From: [Holly Duncan](#)
To: [Dusty Pilkington](#)
Cc: [Holly Myers](#)
Subject: RE: BL-16-00016 Potucek (Disregard previous email, date incorrect)
Date: Thursday, October 27, 2016 11:33:26 AM

From: Dusty Pilkington
Sent: Friday, October 21, 2016 11:44 AM
To: Kelly Bacon; Holly Duncan; Holly Myers; Josh Hink; Lucas Huck; RichElliott; 'eburgwater@yahoo.com'; Dr. Paul Farris, Ellensburg School District; 'fwalker@eburg.wednet.edu'; 'pubworks@ci.ellensburg.wa.us'; 'comdev@ci.ellensburg.wa.us'; 'energyservices@ci.ellensburg.wa.us'
Subject: BL-16-00016 Potucek

**POTUCEK PROPERTY**

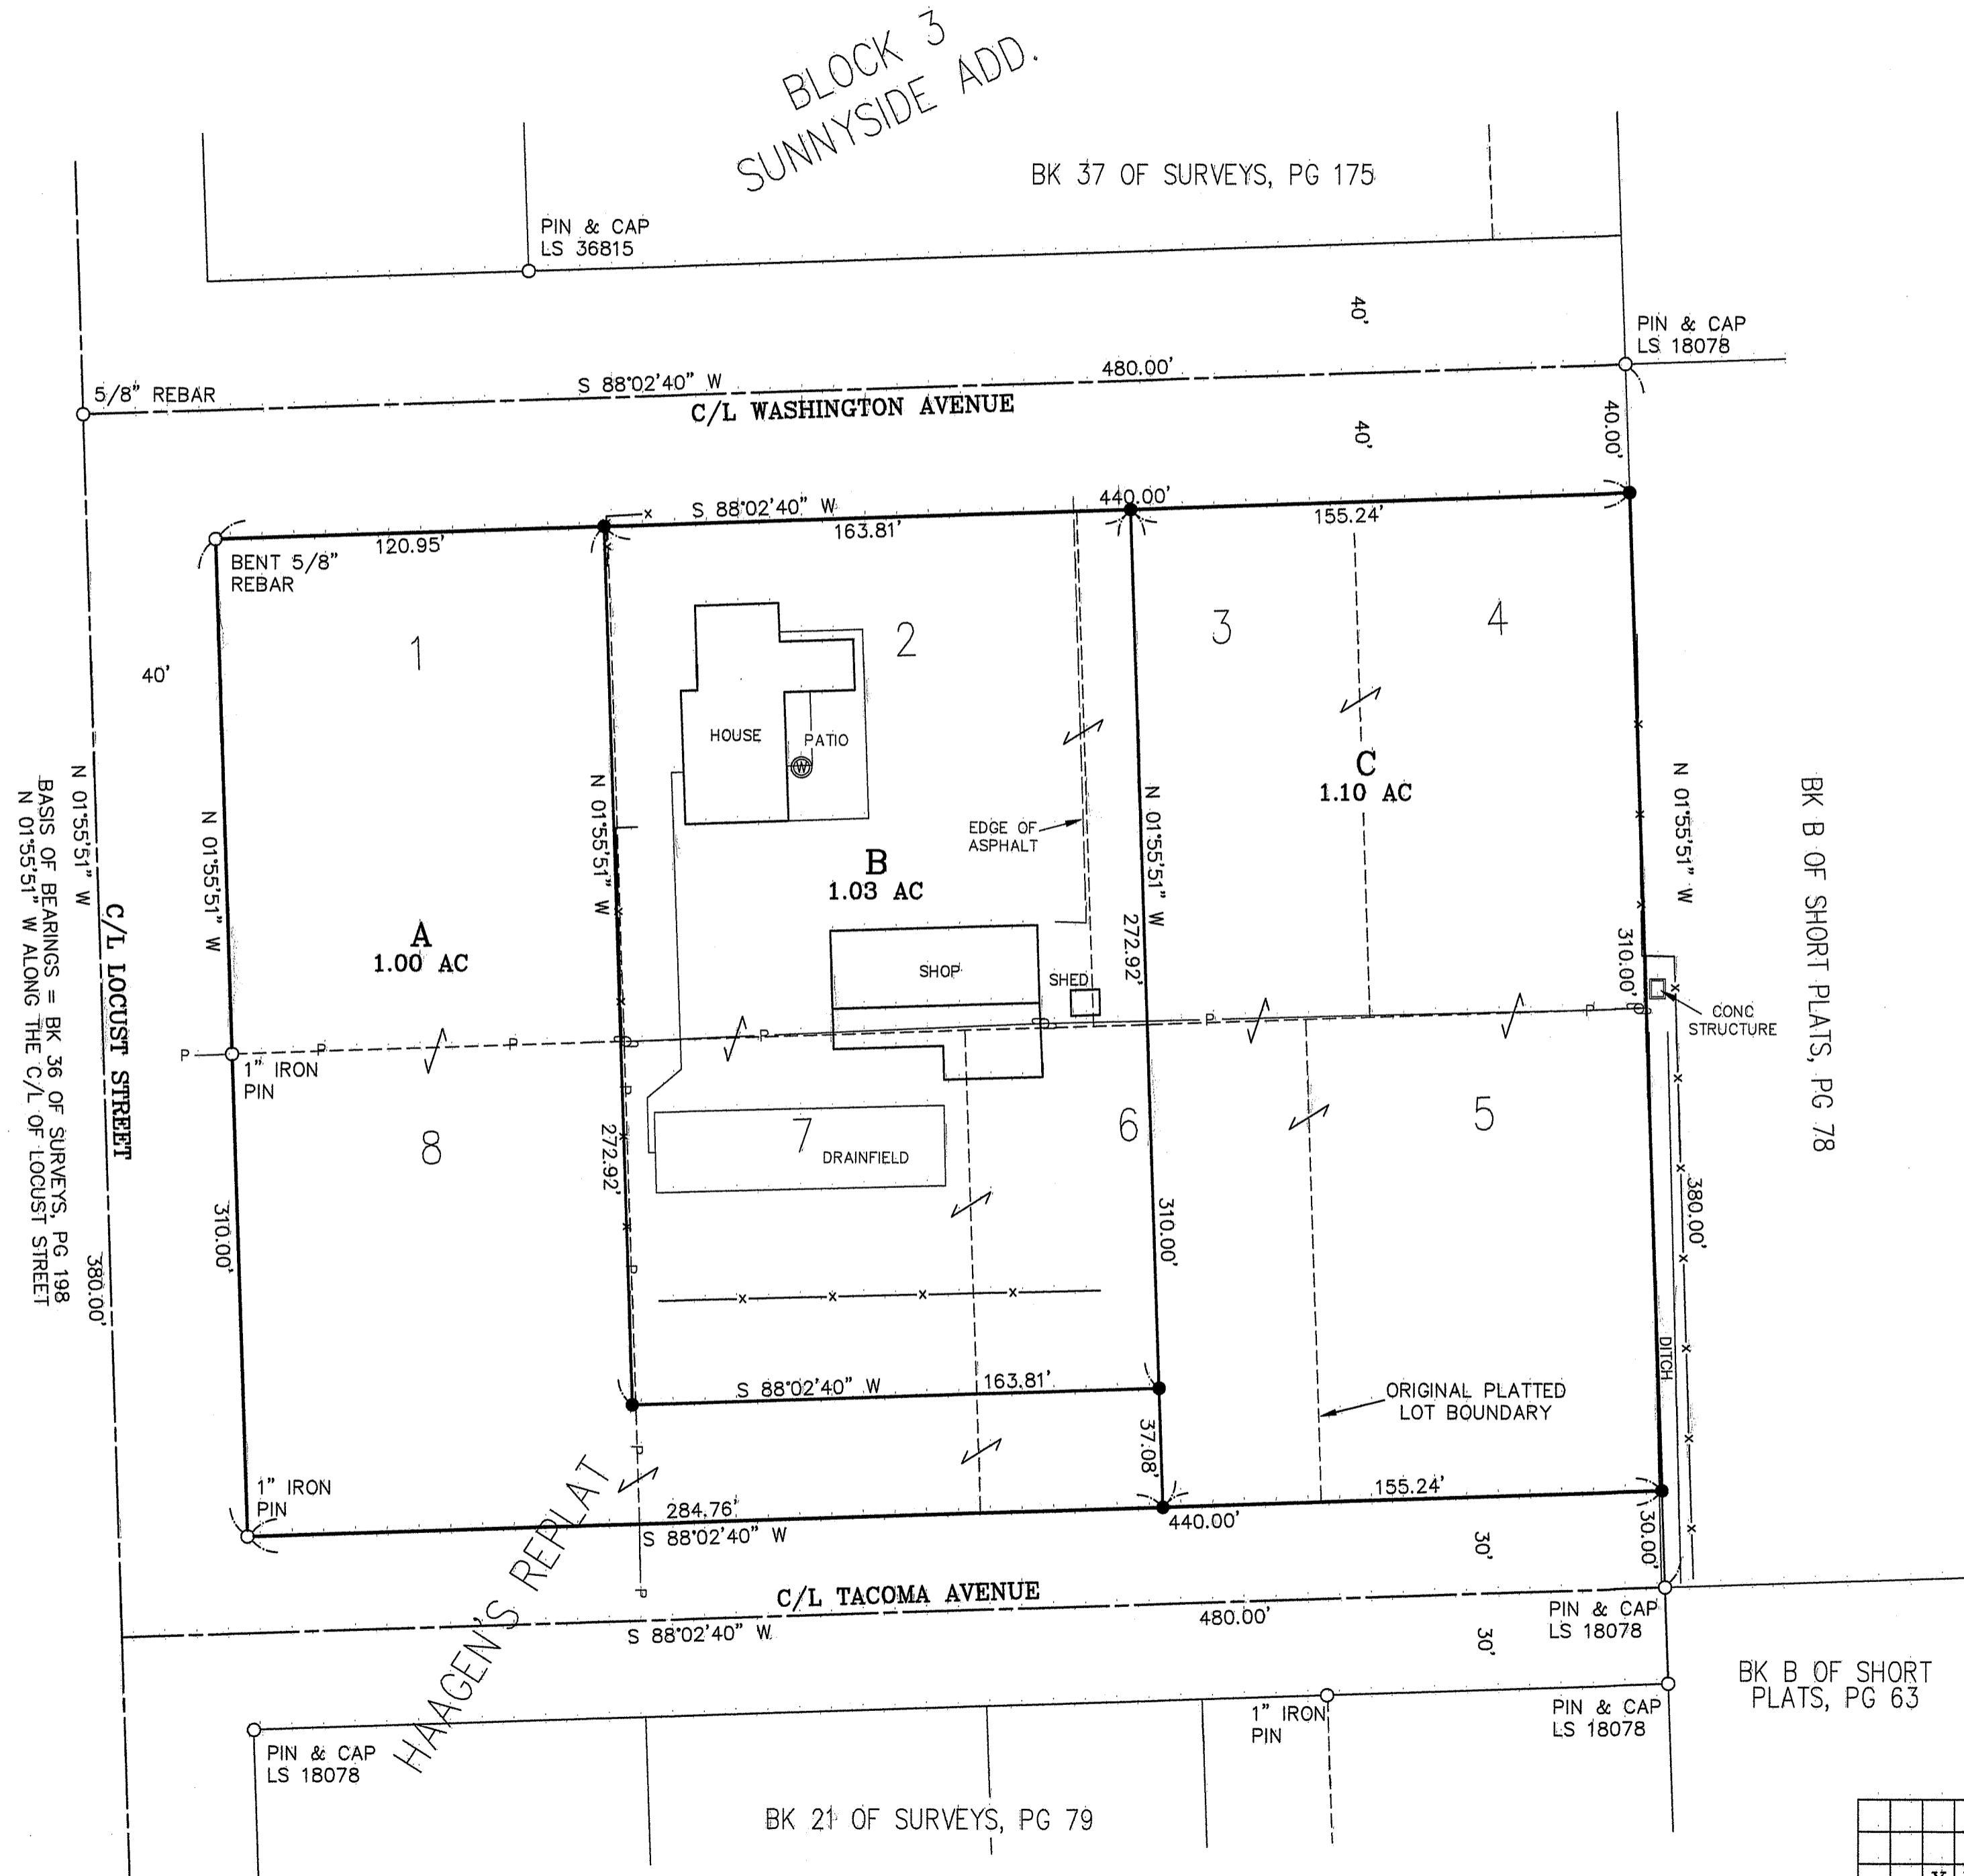
I have reviewed this application and see that the well and future well sites meet all required setbacks. Careful planning will need to be done in the development of lots A and C as the space to work with is very small.
